Our Ref: AB/124/11/A

20th January 2012

Erect 1No. non-illuminated hoarding sign at the site entrance. This application lies within the South Downs National Park Authority.

Arundel Cricket Club Waterwoods Plain Chichester Road Arundel

Proposed Hoarding

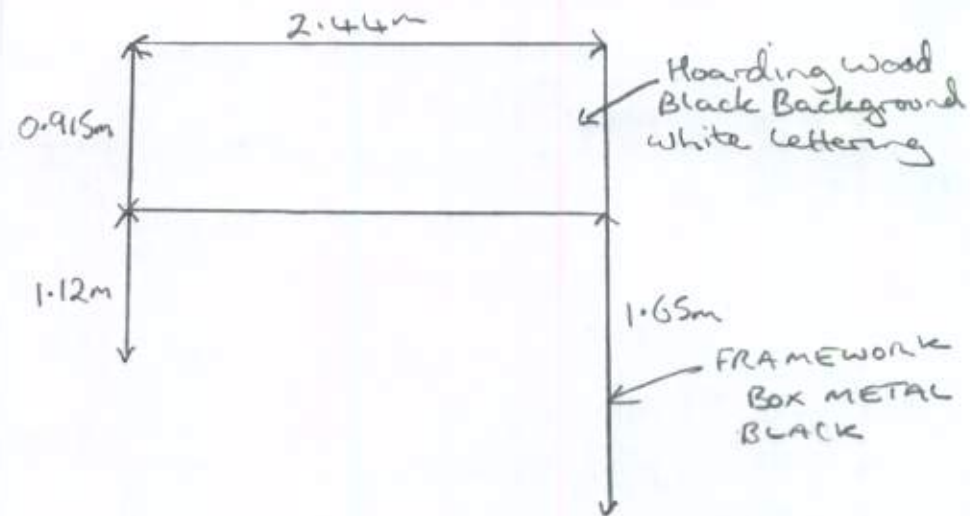
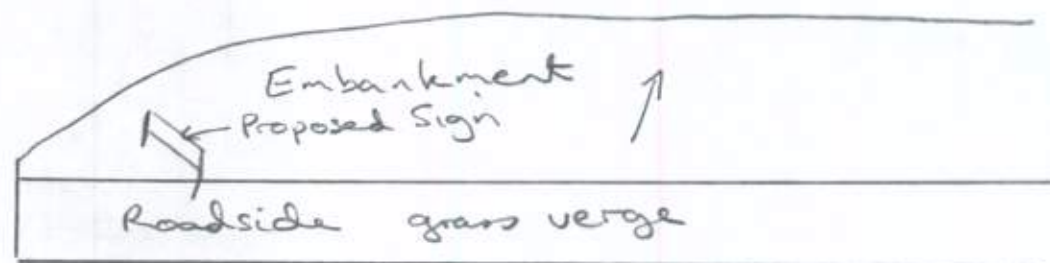
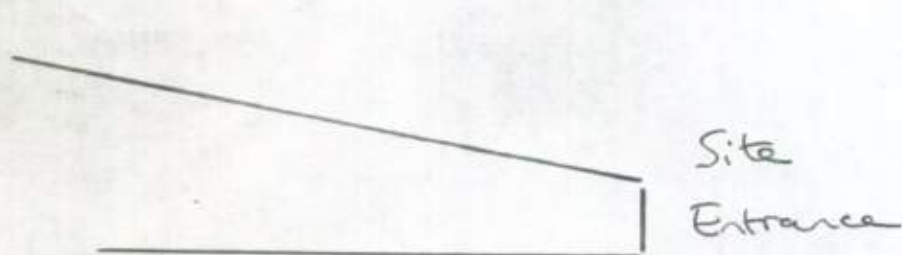
The Committee objected to the application on the grounds that the proposal would be likely to form a distraction to passing drivers that would have an adverse impact upon the safe and efficient operation of this part of the strategic road network
